Case Officer: Sarah Greenall**Recommendation:** Approve**Applicant:** Mr Jason Williams**Proposal:** Discharge of condition 3 (external windows and doors) of 19/01005/F**Expiry Date:** 23 October 2019

- 2.1. The current application seeks to discharge Condition 3 (external windows and doors) of 19/01005/F which was granted permission on 8th August 2019.

5 Typical Window Head, Cill & Glazing Bar Detail
Scale: 1:5

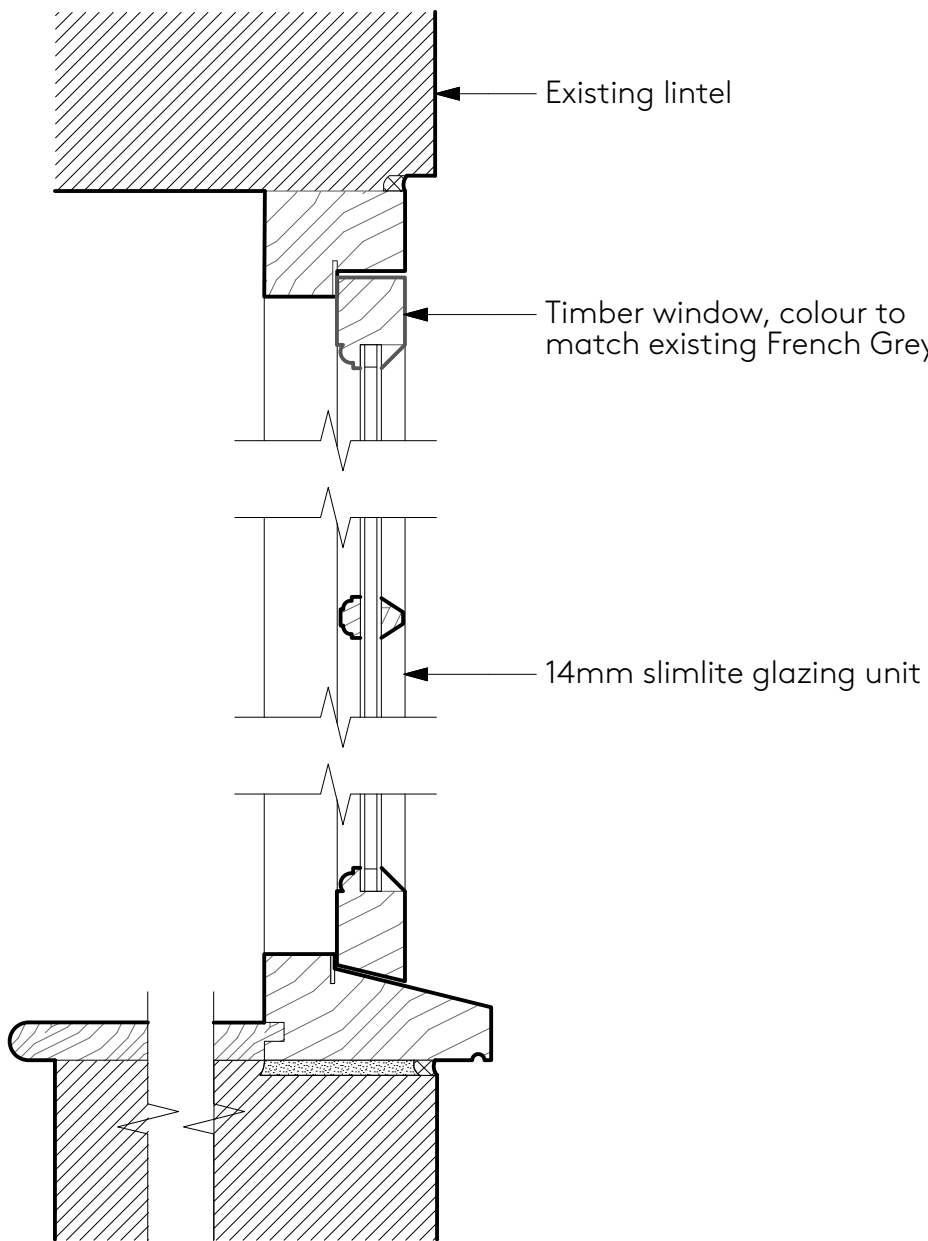
- 6.2. CONSERVATION (CDC): **No objections** providing a true glazing bar is used for the windows and not a stick-on glazing bar.

- 8.1. Condition 3 required that full joinery details of the windows and doors should be submitted to and approved by the Local Planning Authority prior to the commencement of the development. The Conservation Officer initially raised concern over the fact the window detail appeared to show a stuck-on glazing bar which would not be suitable for a listed building. However, the applicant clarified that a true glazing bar would be used with individual panes of glass and additional plans were submitted to reflect this. The window and door details are therefore considered to be acceptable.

Condition 3 – Windows/doors in accordance with drawings 1, 2, 3 and for shown on drawing No. P11, glazing bar plan submitted via email on 02.10.2019 and Glazing bar detail – Elm Tree House submitted via email on 22.10.2019.
